Yorkshire
Wildlife Trust

15th November 2013

Application by Able Humber Ports Limited for an Order granting Development Consent for the Able Marine Energy Park

Cherry Cobb Sands Wet Grassland

Figure Title  
Existing Site Conditions

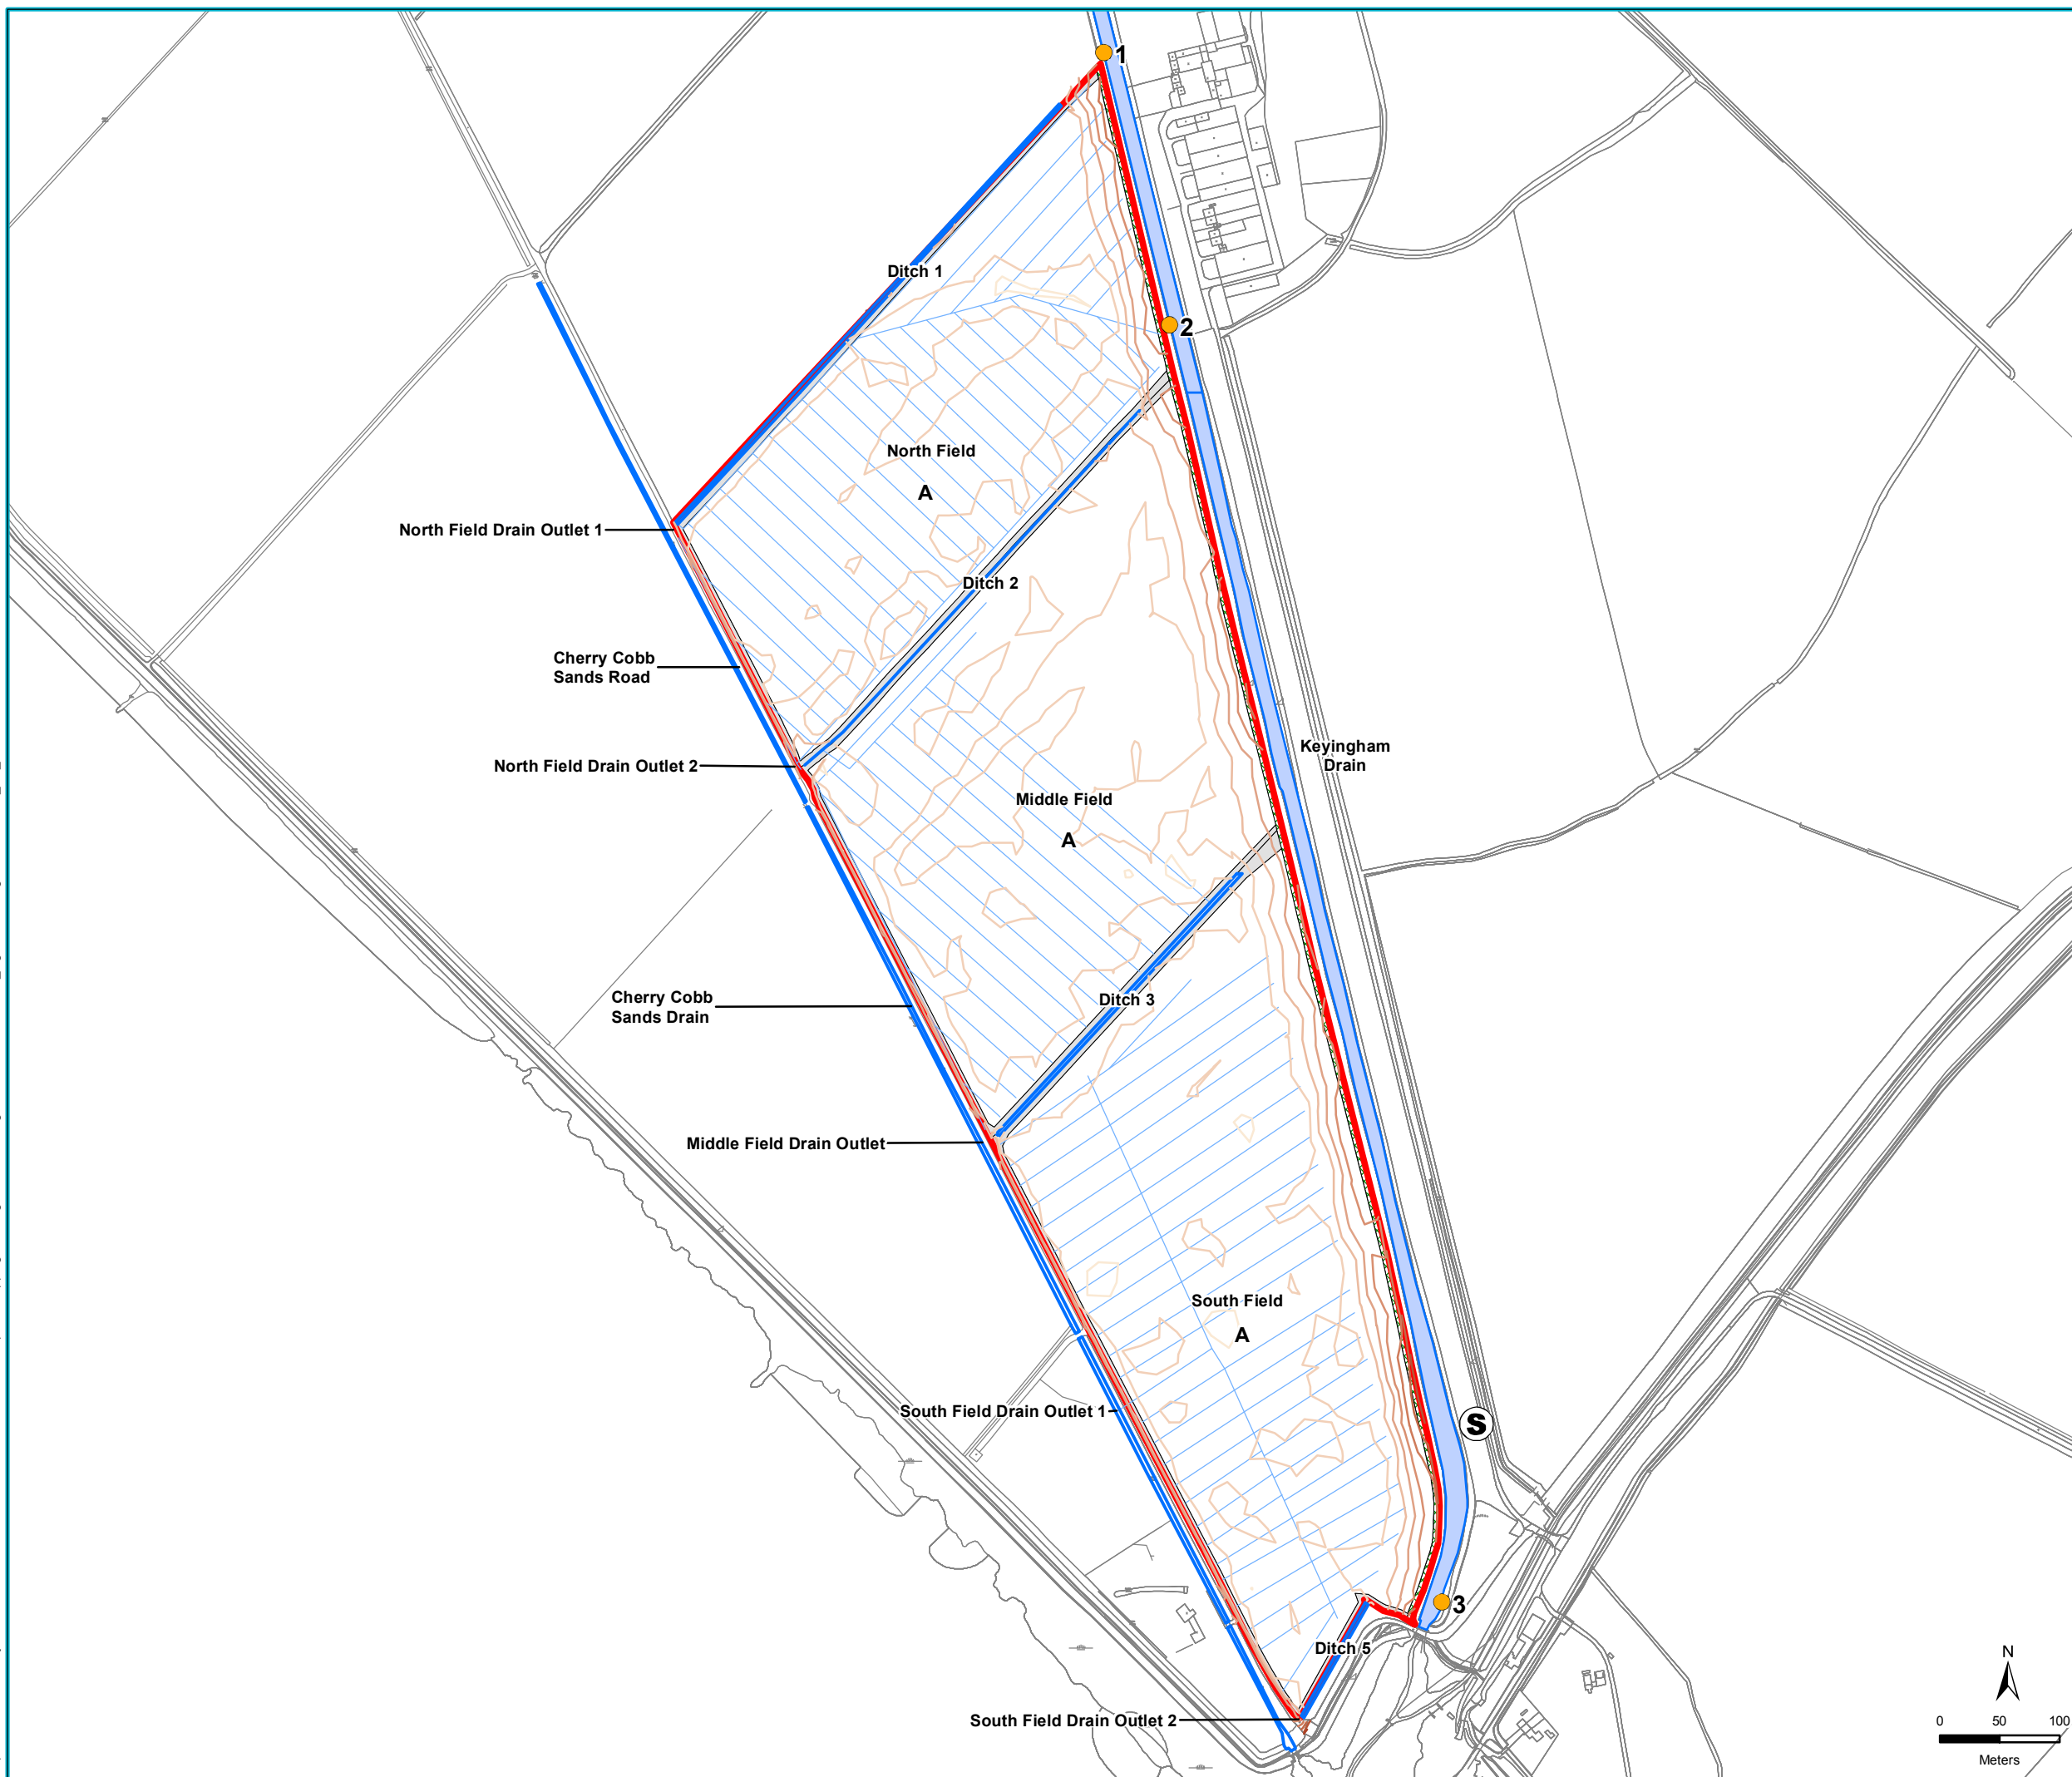
Overhead cables - The overhead cables in the south east corner may be a barrier for birds entering the site as this area is the closest section to the estuary/existing mudflats. In poor weather conditions the risk of collision is likely to be increased. We would recommend that these cables are rerouted underground.

Disturbance – There are already a number of people visiting the area and parking on the roadside and this is only likely to increase as the site attracts more birds. To reduce the level of disturbance to the birds, and congestion of the road, provision should be made for managed public access with hides/screens and parking. We would be happy to provide further advice on this.

Figure Title Finished Layout

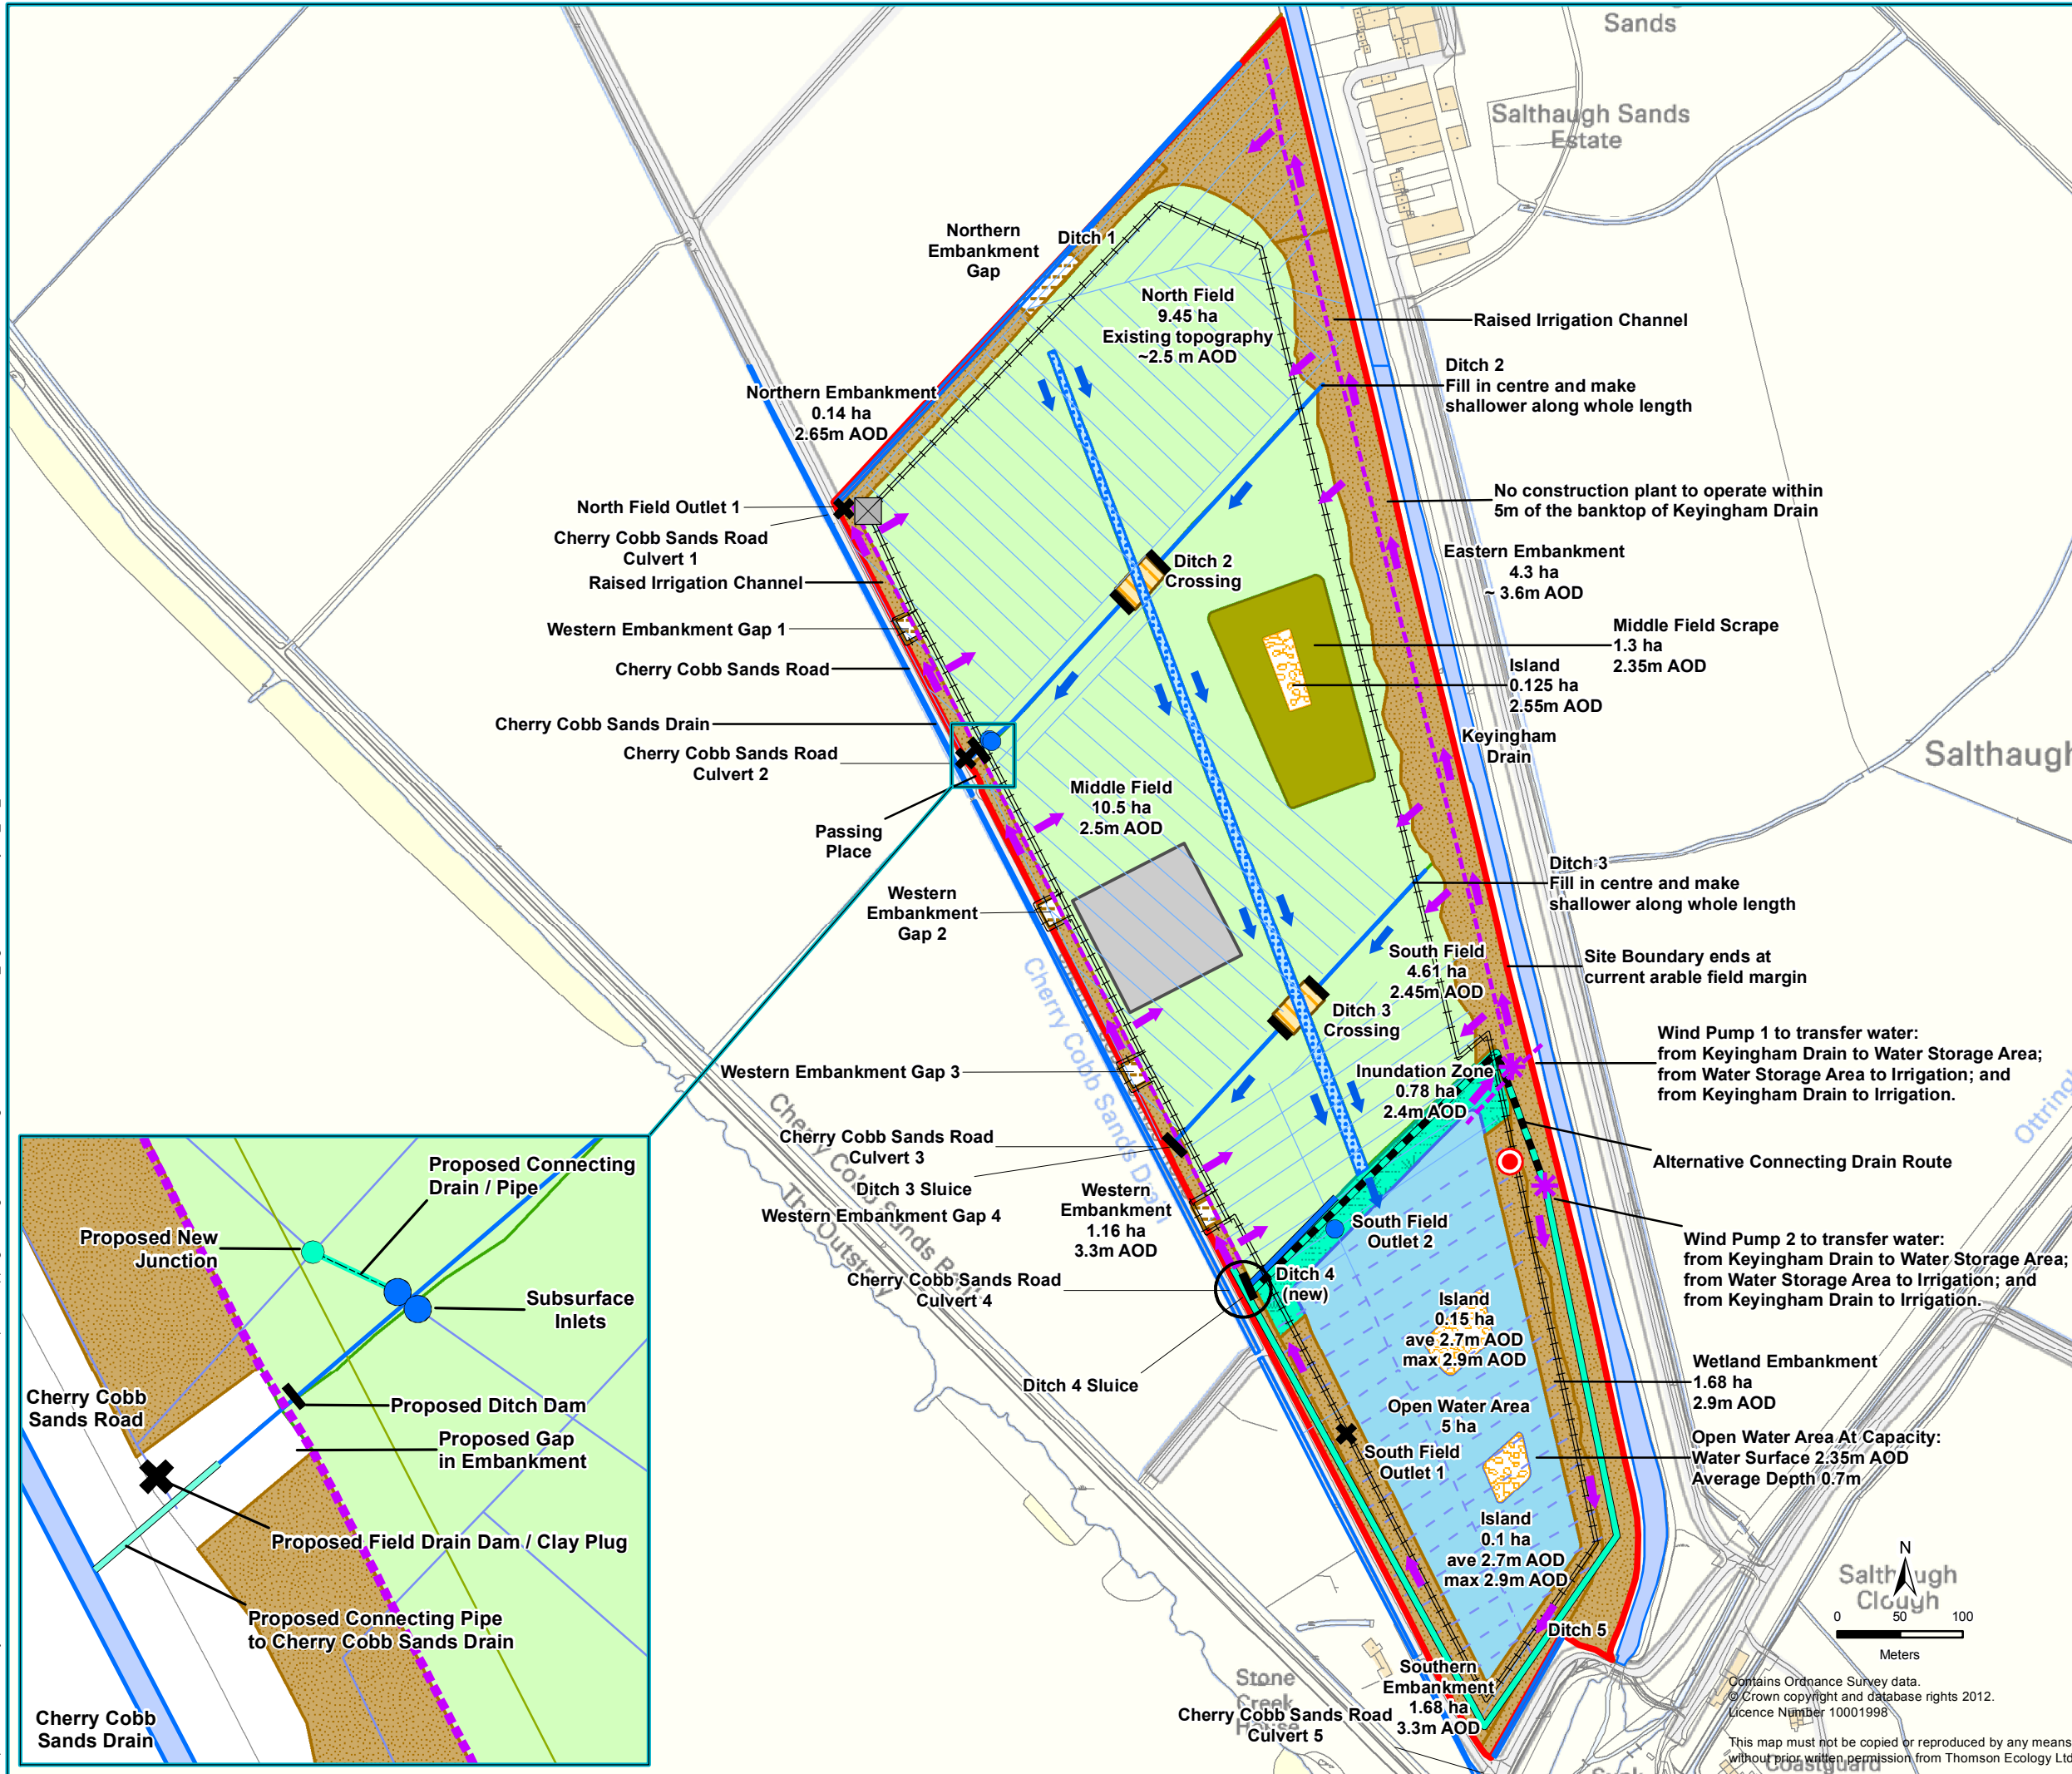
Design – We would recommend a more sinuous drainage design which maximises the shallow edge that wet grassland invertebrates prefer and therefore increases the value for the target species.
